Approval of details reserved by condition imposed under ref W/4001228 (BN/24/20/PL) relating to Condition Nos 3 - materials and finishes, 5 - noise, 6 - dustbin enclosure, 7 - renewable energy, 10 - covered & secure cycle parking, 11 - electric vehicle charging, 12 - surface water drainage and 13 - foul drainage.

Tile Barn Farm 32 Hill Lane Barnham PO22 0BL

Condition Number 10

Arun District Council have decided to **APPROVE details reserved by this condition**

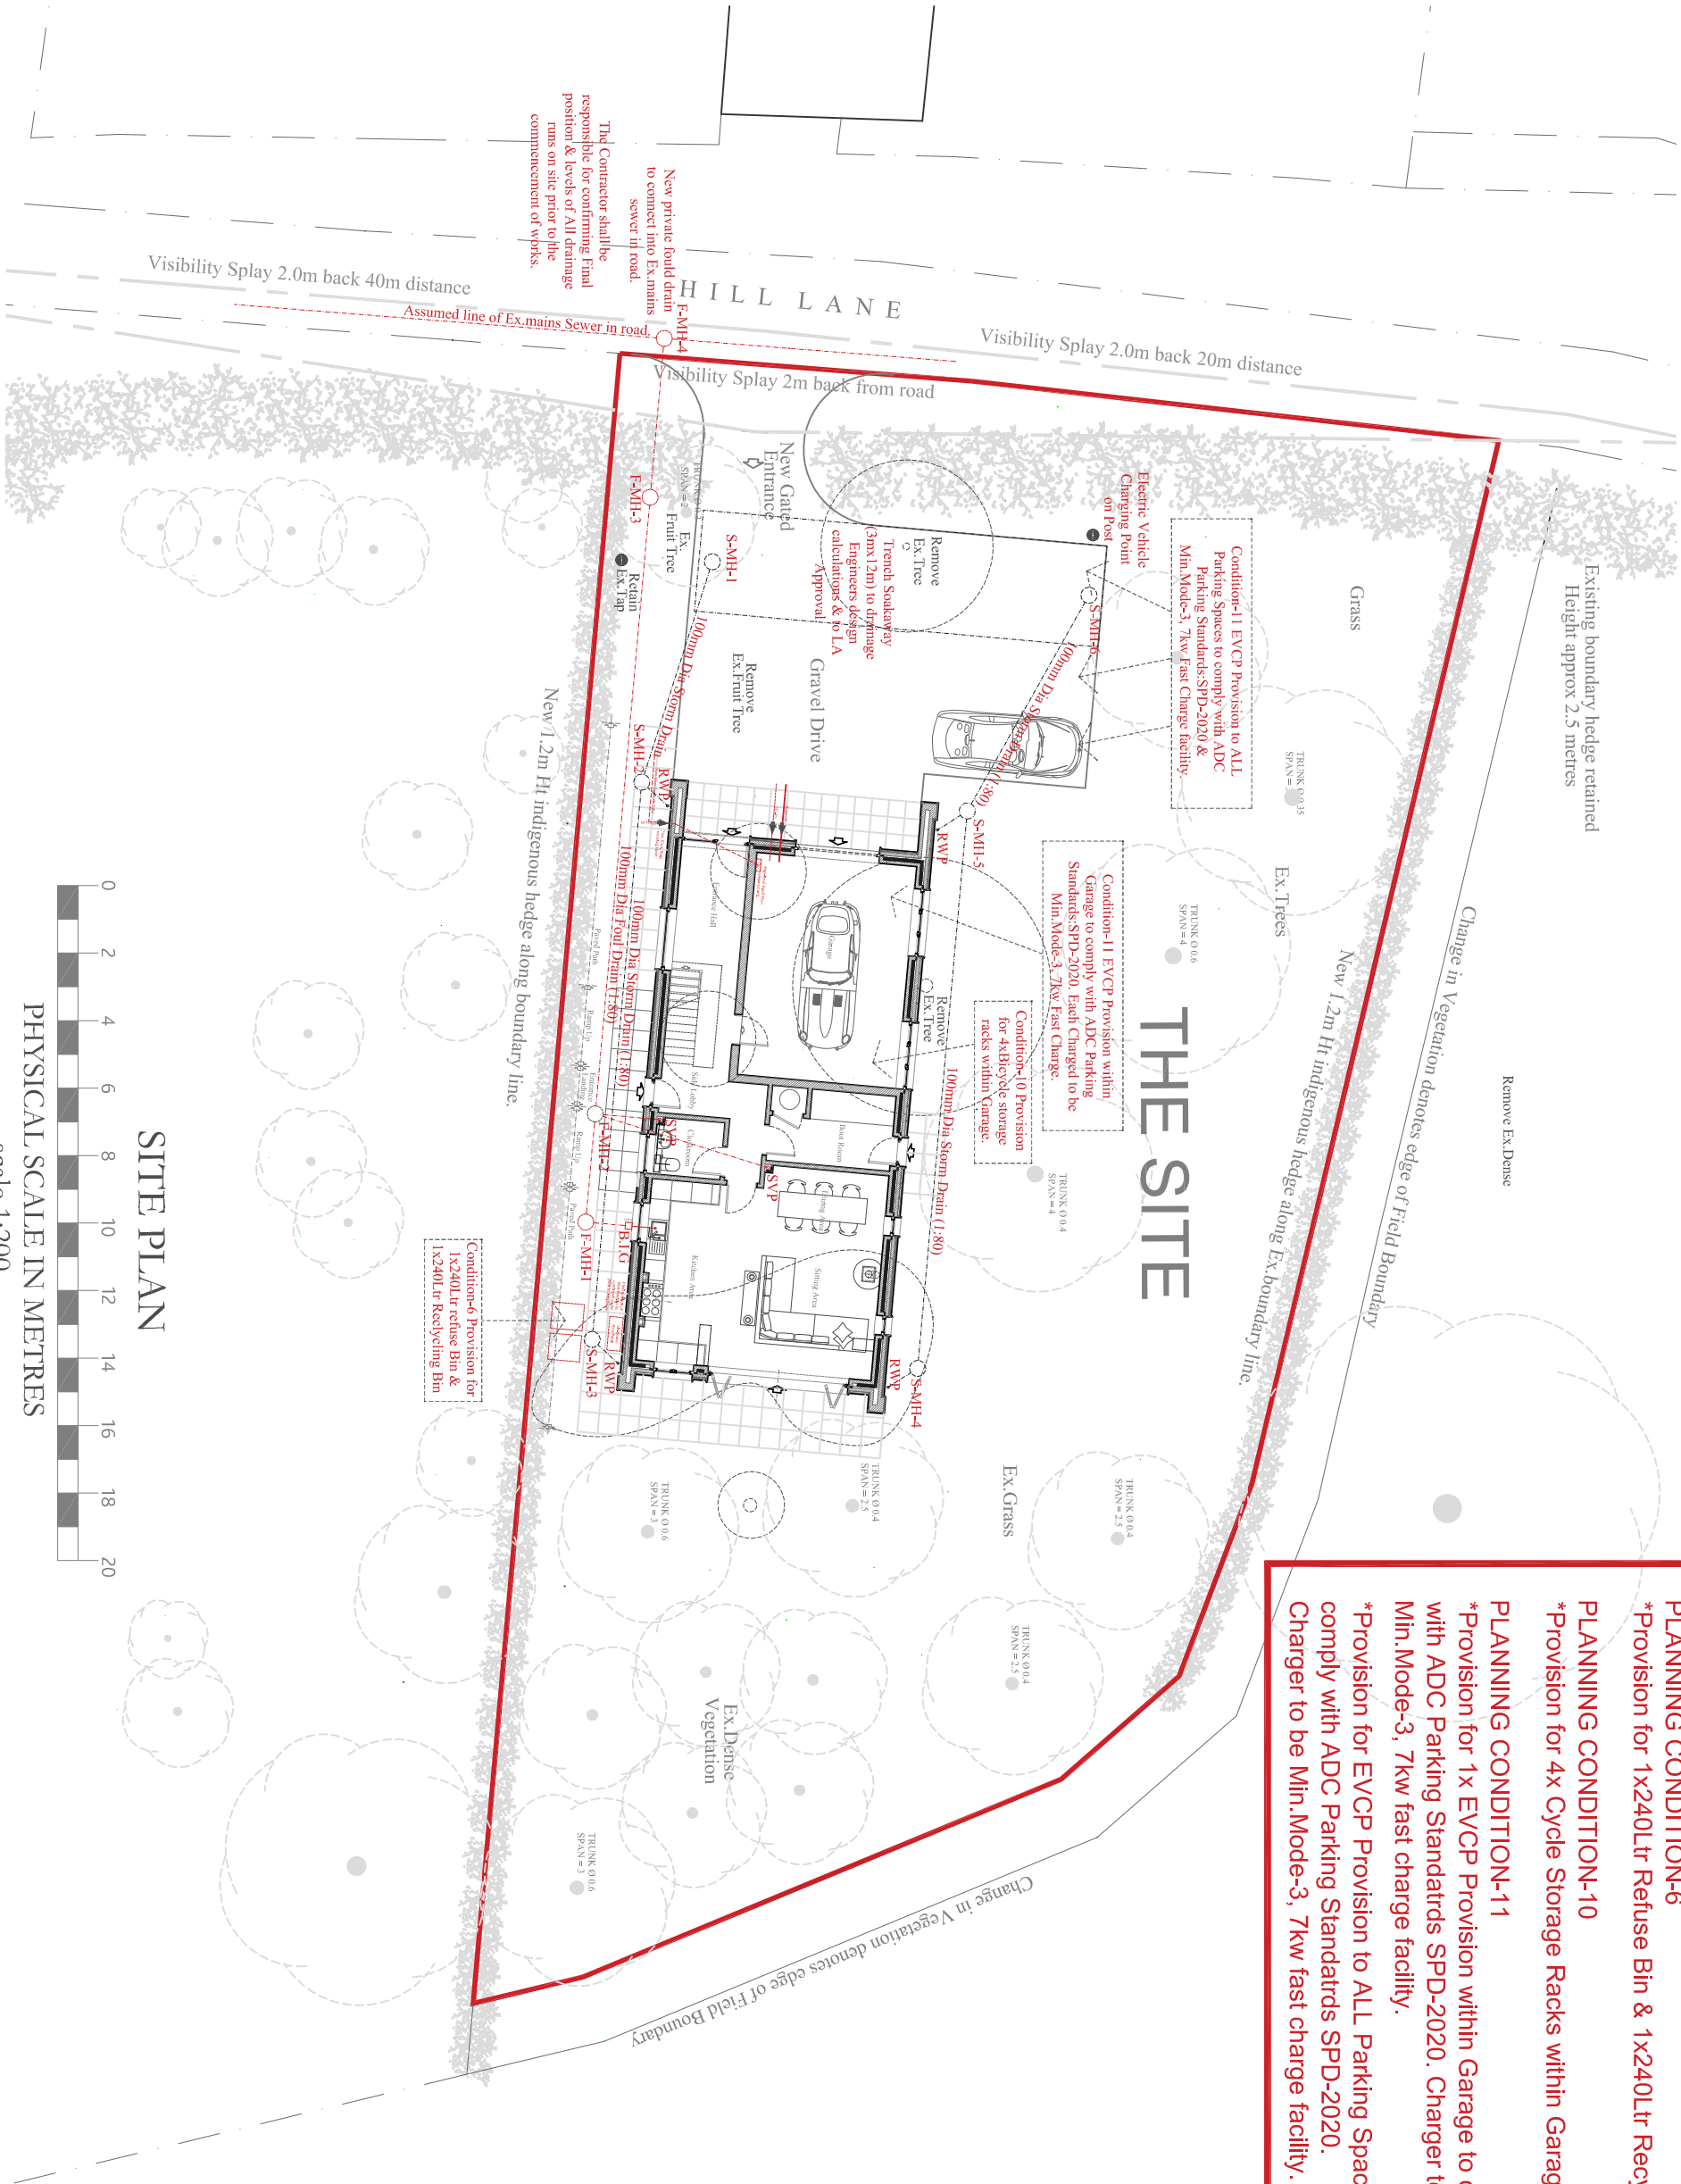
Officer comment: The revised drawings show 4 cycle racks will be provided within the garage so will be undercover and secure. WSCC Highways have confirmed garage is sufficient size to accommodate cycle parking.

The discharge of this condition (10) which relates to covered and secure cycle parking is approved in accordance with the following documents:

- Site Plan (revised and received 18.11.2021)
- Ground Floor Plan (revised and received 18.11.2021)
